Recommendation Report for Planning Permission for Works or Extension to a Dwelling

REF NO: FG/112/21/HH

LOCATION: 46 Ferringham Lane
Ferring
BN12 5LU

PROPOSAL: Erection of a detached single garage, front wrap around crown roof and internal remodelling

Title:
Detached Single Garage,
Internal Remodel & Front
Wrap around Crown Roof.

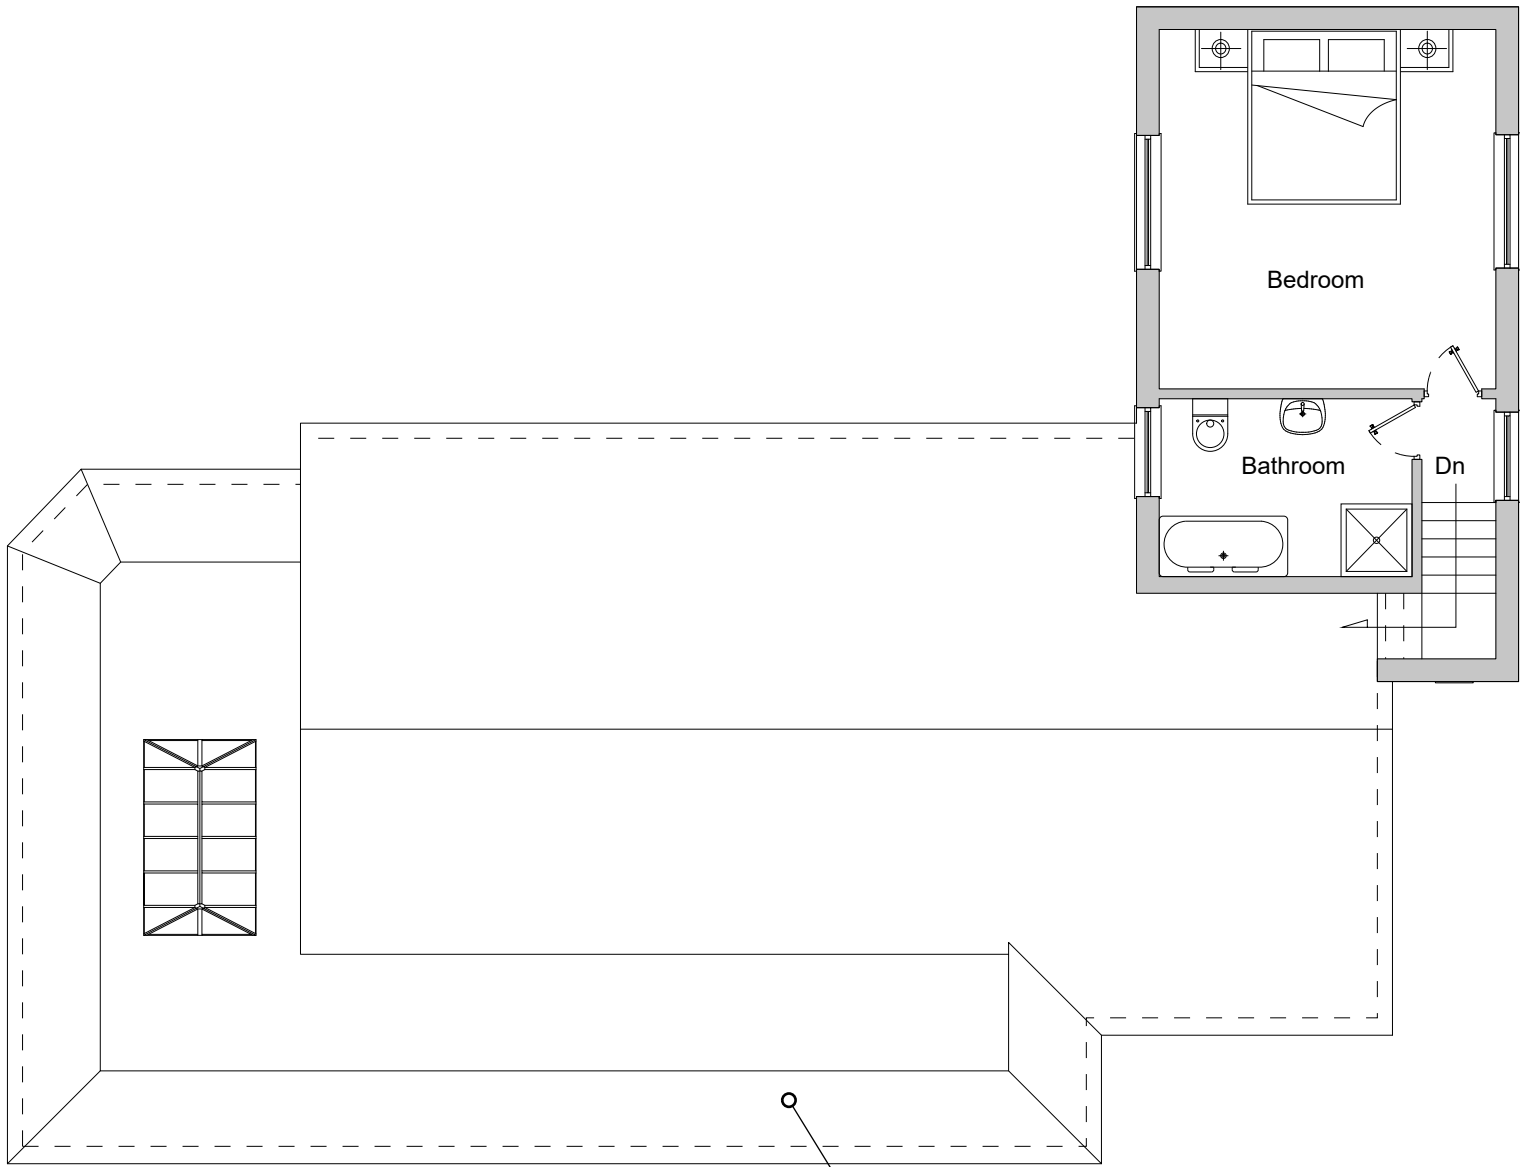
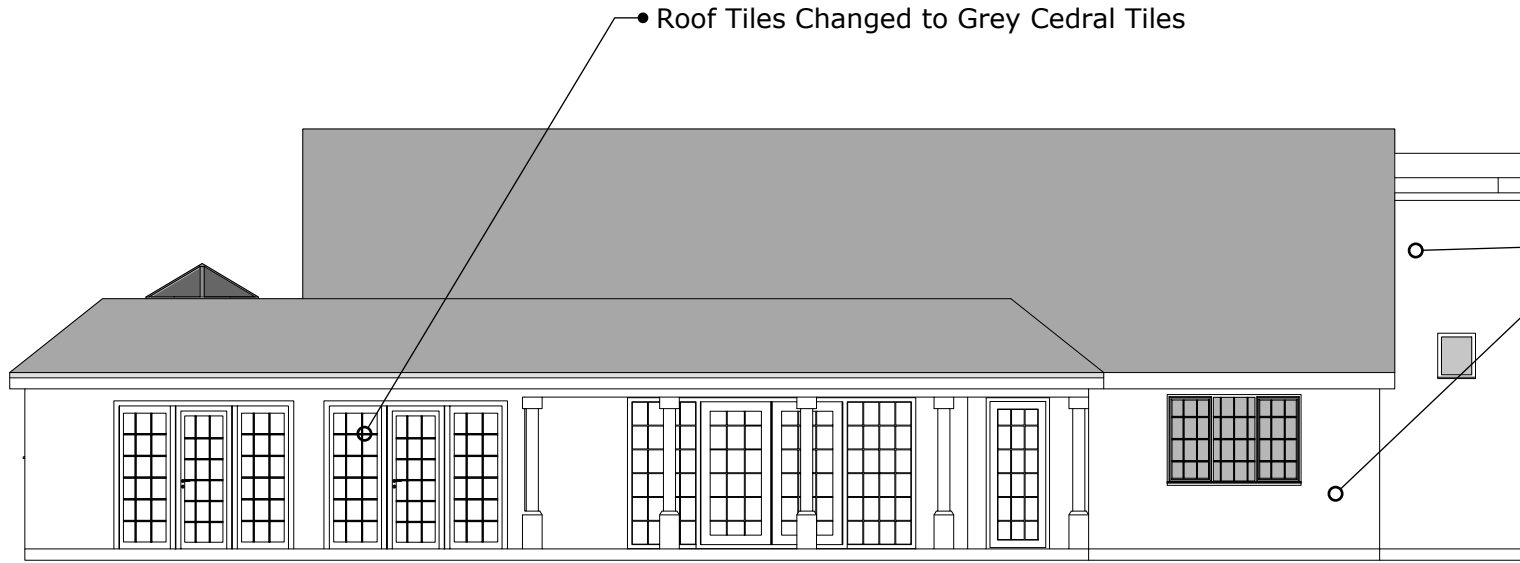
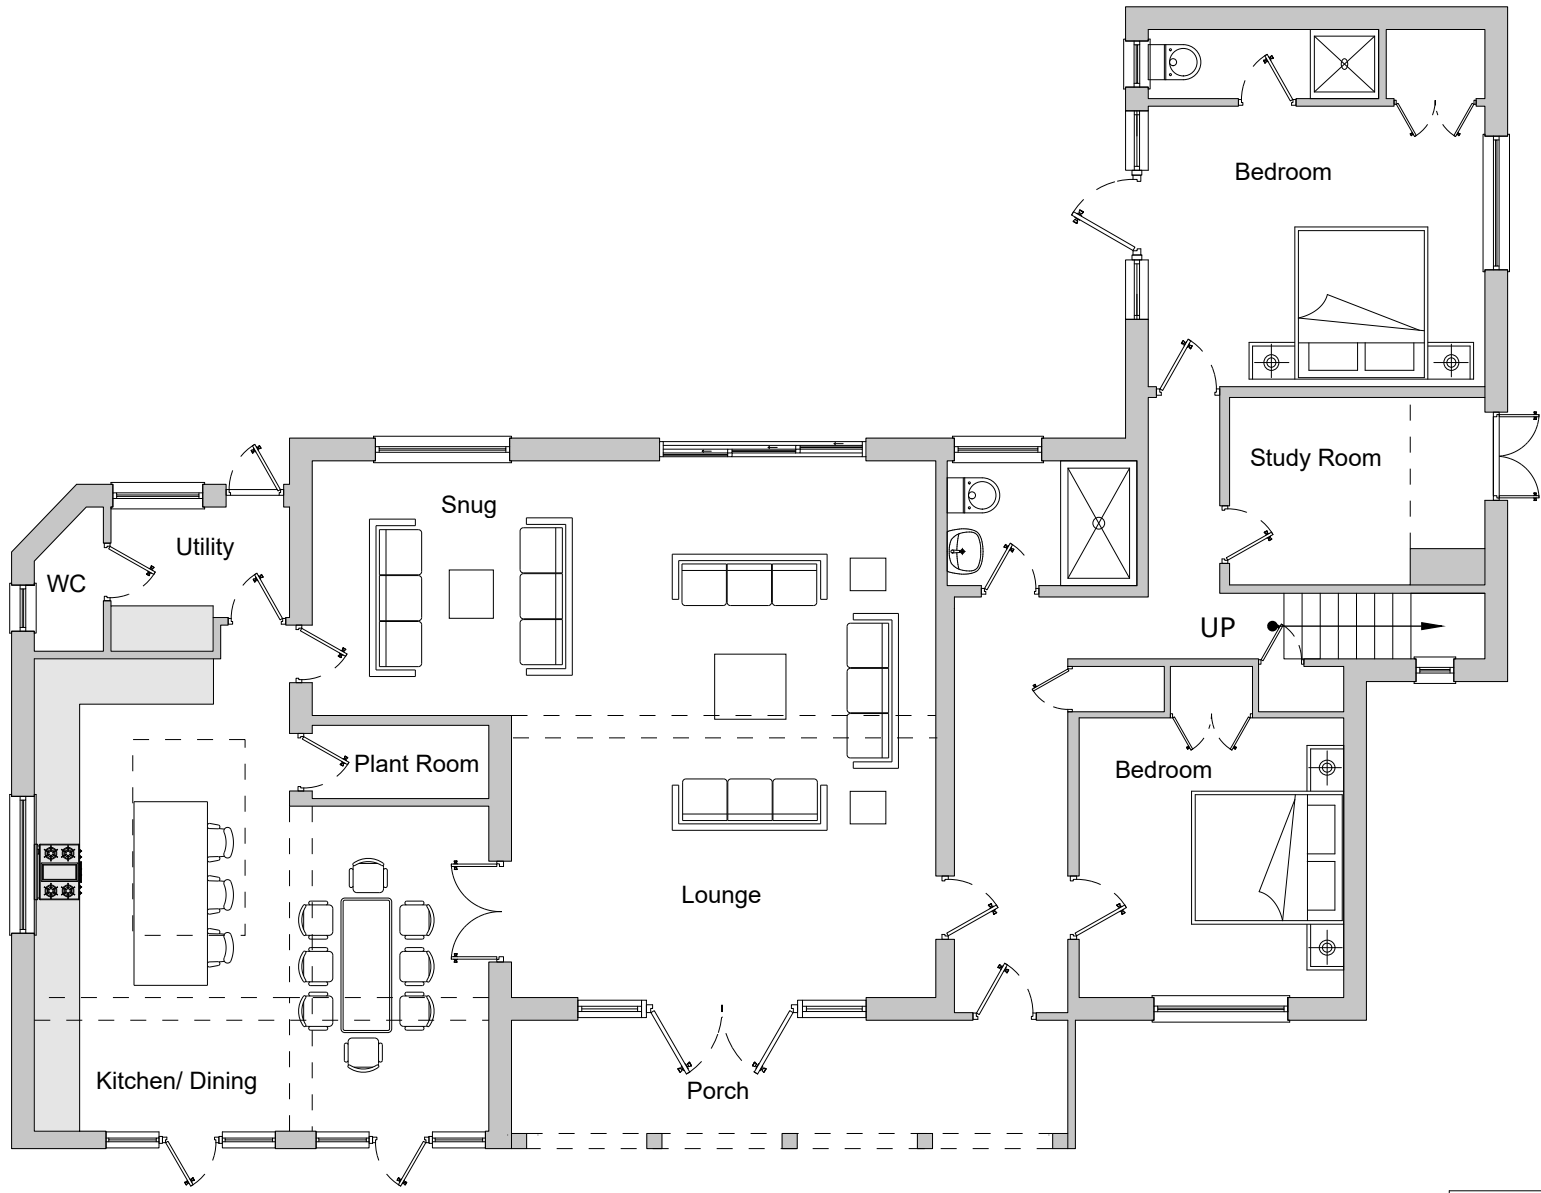
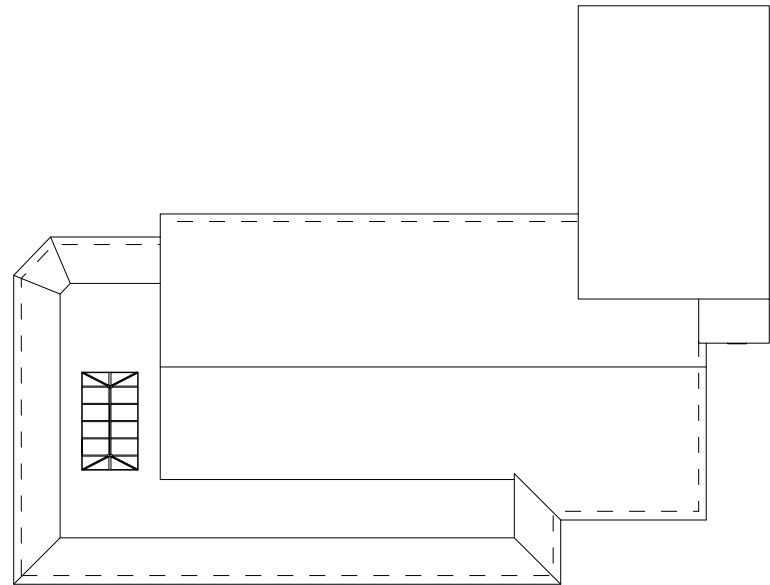
The dwelling has an existing wrap around extension with a flat roof and the proposal seeks to alter the roof from flat to form a crown roof.

The alteration would be readily visible from the street scene however is modest in size, with the height increasing by approximately 1.1m to 3.35m. With around 27m retained to the front boundary, the alteration will not appear unduly dominant upon the front elevation of the dwelling and would not result in harm to the character or appearance of the area and is acceptable.

The alteration to the roof would appear subservient to the dwelling as a result of its visual integration with the dwelling in terms of siting, massing, form and scale. The eaves height would match that of the host dwelling, along with the materials.

There would be a rooflight to the western side however it would not significantly alter the appearance of the front of the dwelling and would not appear out of character in the area.

The alteration of the wrap around extension to form a crown roof, will increase in height of the roof, however the increase is modest and given the aspect of the development site and the host dwellings' relationship with neighbouring dwellings, the roof alteration would not result in overbearing or overshadowing upon neighbouring properties.

There is one additional ground floor window proposed in the western elevation but this serves a toilet (wc) and would have obscure glazing, and would not result in any undue loss of privacy or any overlooking of neighbouring dwellings.

A 03

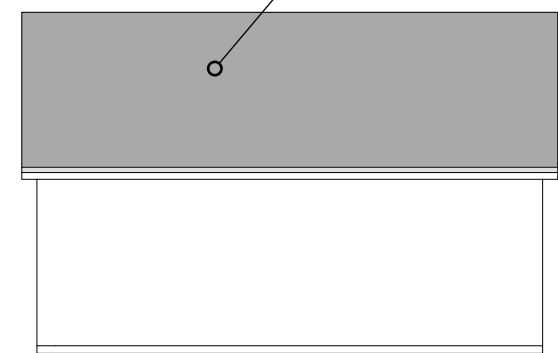
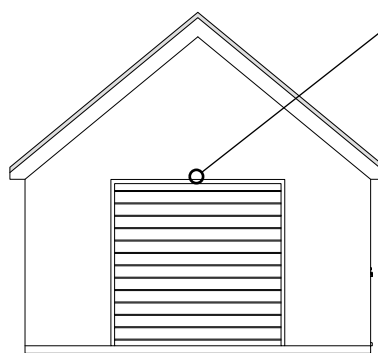
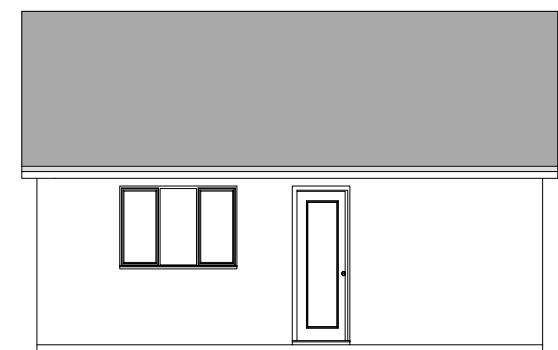
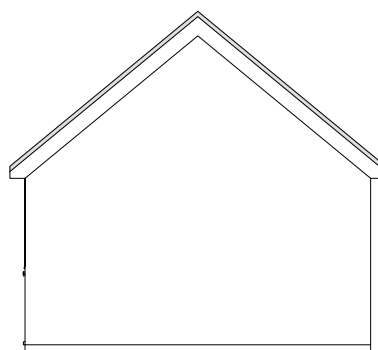
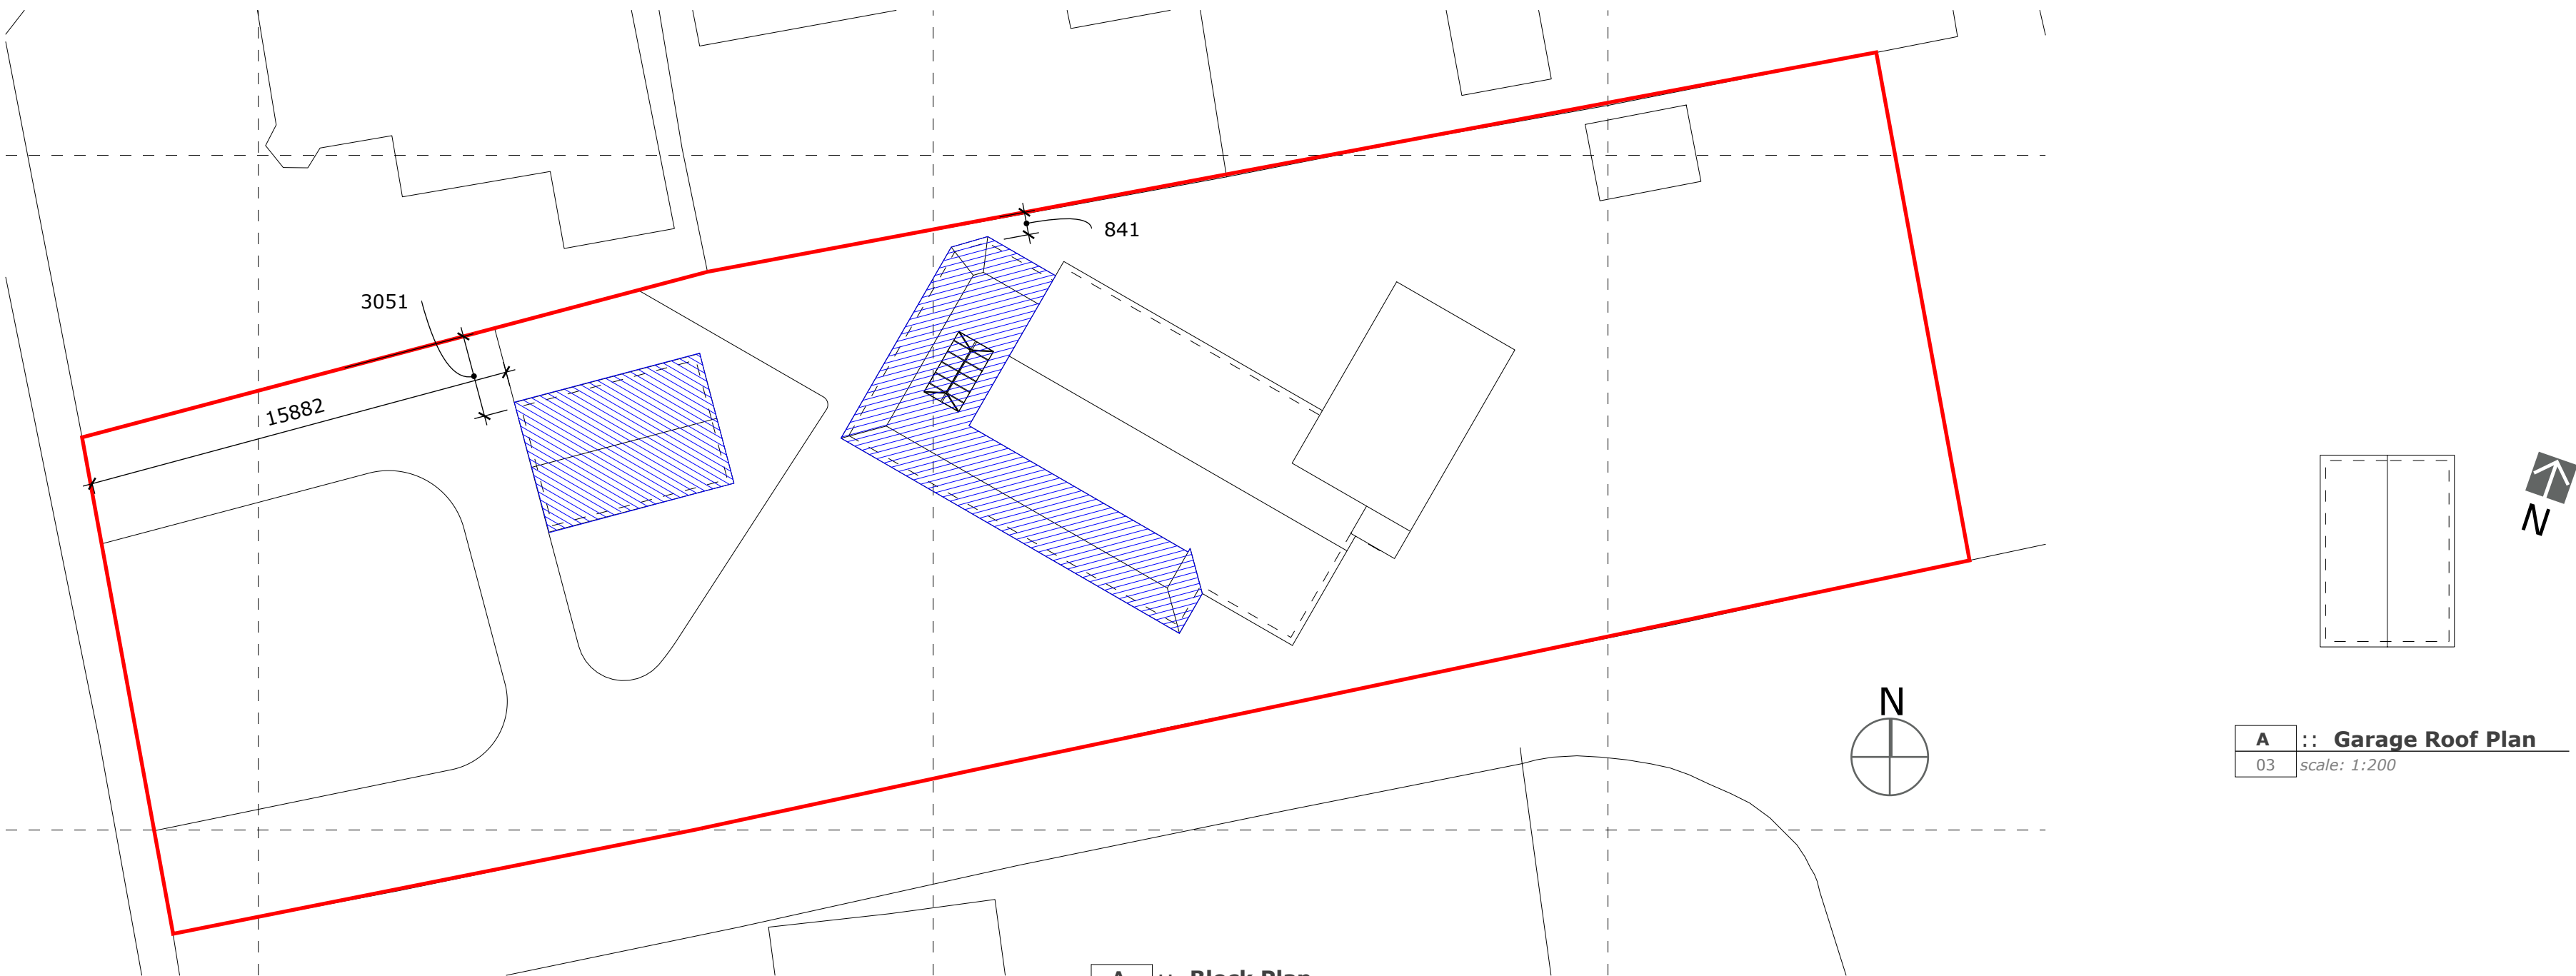
A garage is also proposed, forward of the principle elevation. This will be detached from the dwelling and located 15m behind the front boundary of the property. There is a brick wall which curves around the entrance of the site and with sufficient planting, much of the view of the garage will be screened from the street scene and therefore whilst it adds some bulk to the property, this is not considered significant and is acceptable.

The proposed garage will have a pitched roof with a height of 4.5m. This retains 3m to the closest neighbouring boundary to the north. The height has been reduced following advice and it has been moved further from the boundary. No 48 Ferringham Lane sits relatively close to the boundary however the position is considered acceptable in such that it would not give rise to adverse overbearing or overshadowing upon neighbouring windows in which a refusal is justified. There is also sufficient planting along the northern boundary which further helps to screen the proposal.
